## WEST SUSSEX COUNTY COUNCIL CONSULTATION

<b>TO:</b>	Arun District Council FAO: Jessica Riches
<b>FROM:</b>	Stephen Gee WSCC – Highways Authority
<b>DATE:</b>	3 December 2024
<b>LOCATION:</b>	Land at Ford Airfield Ford
<b>SUBJECT:</b>	F/16/24/RES Approval of reserved matters following outline permission F/4/20/OUT for phase reserved matters 4 (south), for the erection of 357 No. residential dwellings plus associated roads, infrastructure, parking, landscaping, open space & play areas and associated works. This application affects a Public Right of Way, may affect the setting of a Listed Building and falls within CIL Zone 1 (Ford strategic site - zero rated).
<b>DATE OF SITE VISIT:</b>	n/a
<b>RECOMMENDATION:</b>	More Information

The application is for the approval of reserved matters for 357 dwellings at Ford Airfield. The site forms part of a strategic allocation of 1500 homes approved under reference F-4-20.

Figure 9: Final Coloured Site Layout for Phase 4
Source: FINC Architects

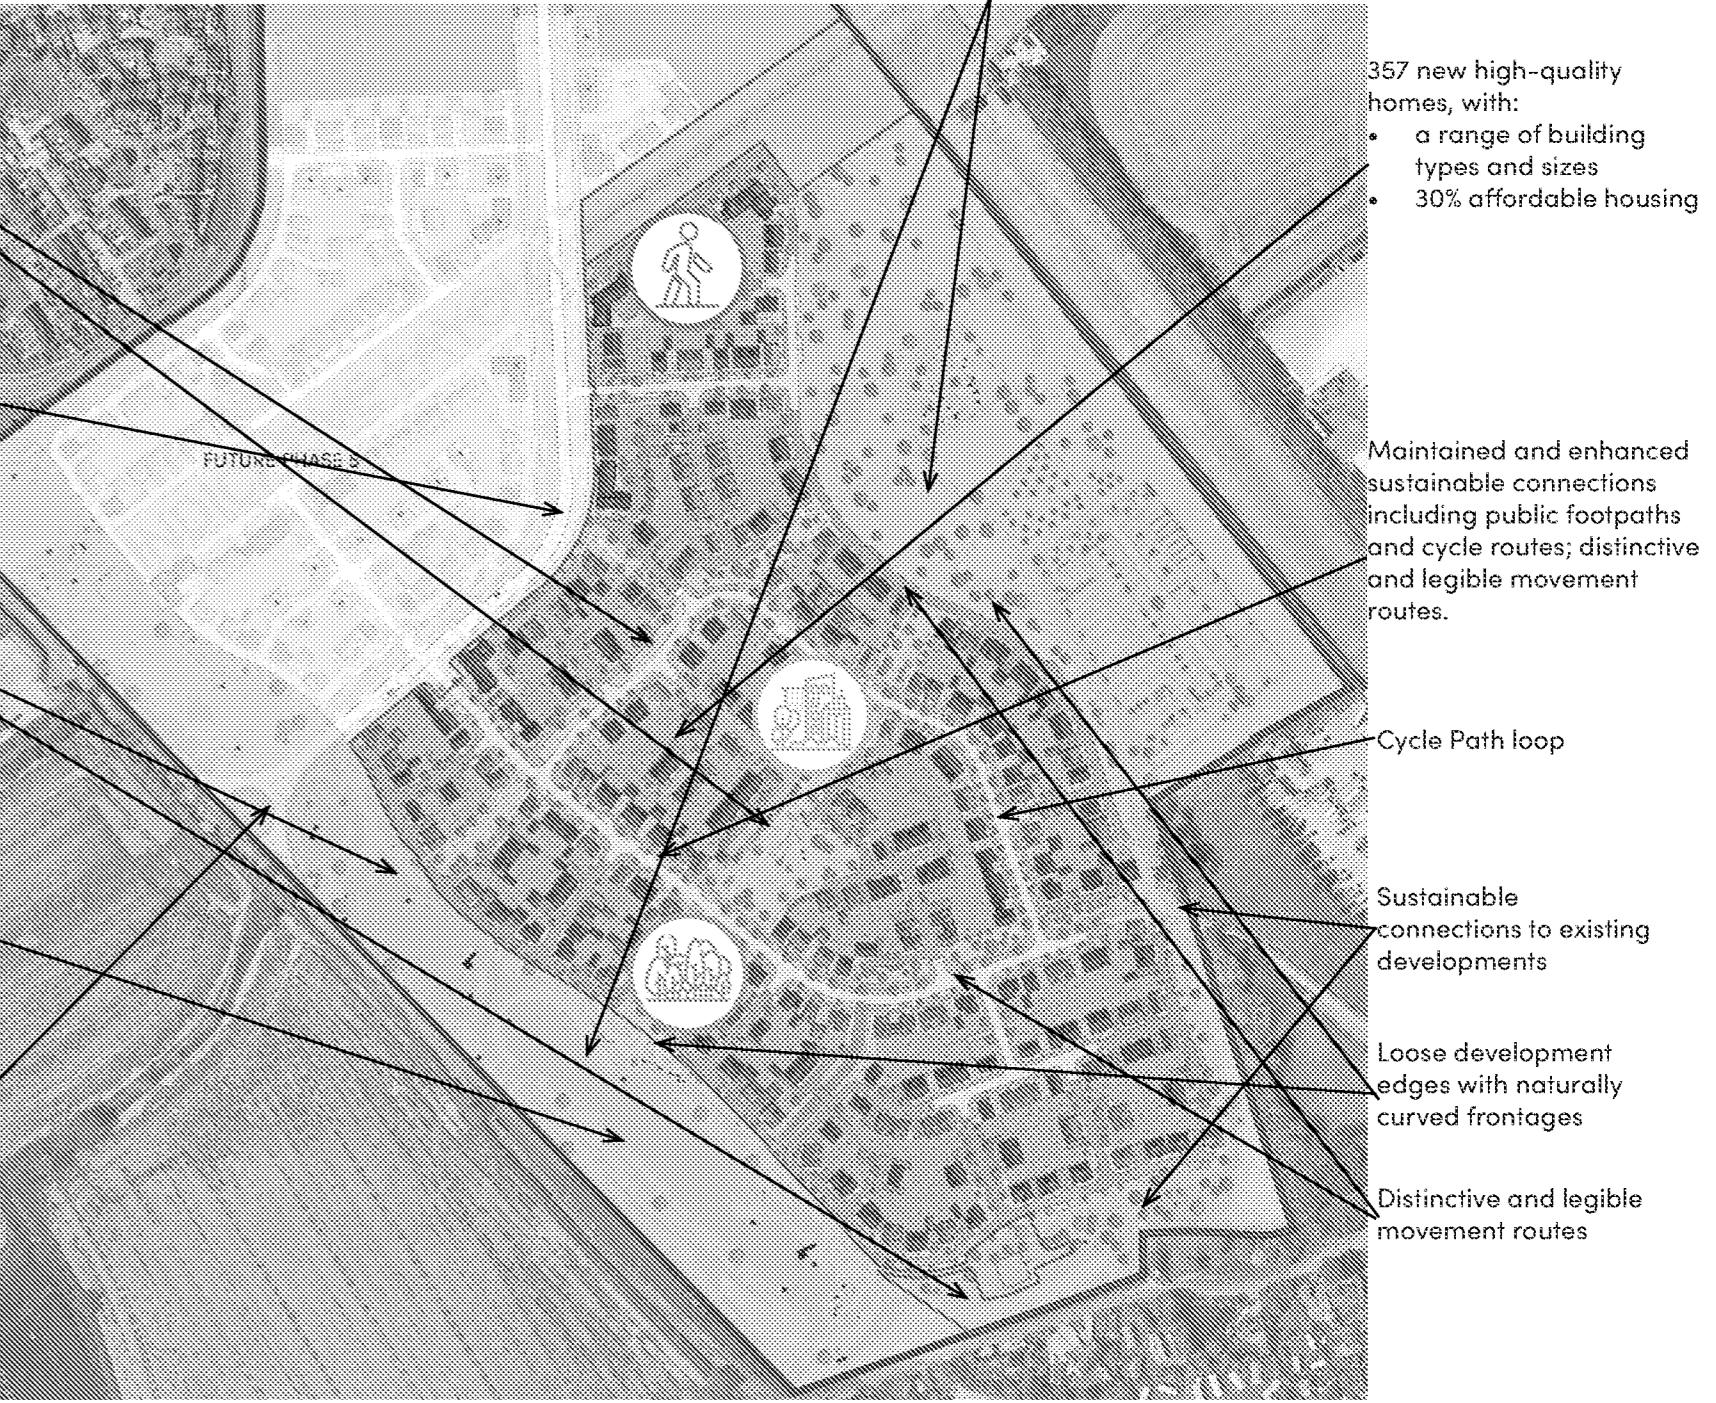
The visitor parking spaces could be better spaced out throughout the development, there tends to be a over provision of spaces towards the extremities of the phase.

In a number of locations trees are to be found in the visibility splays of junctions, whilst this is acceptable with the provision of slim stem and appropriate height trees some very minor adjustments could remove the trees from the splays. It is also noted in other areas the cumulative effect of two trees may impact on the acceptability of the splay some minor movement a proposed trees could remedy this.
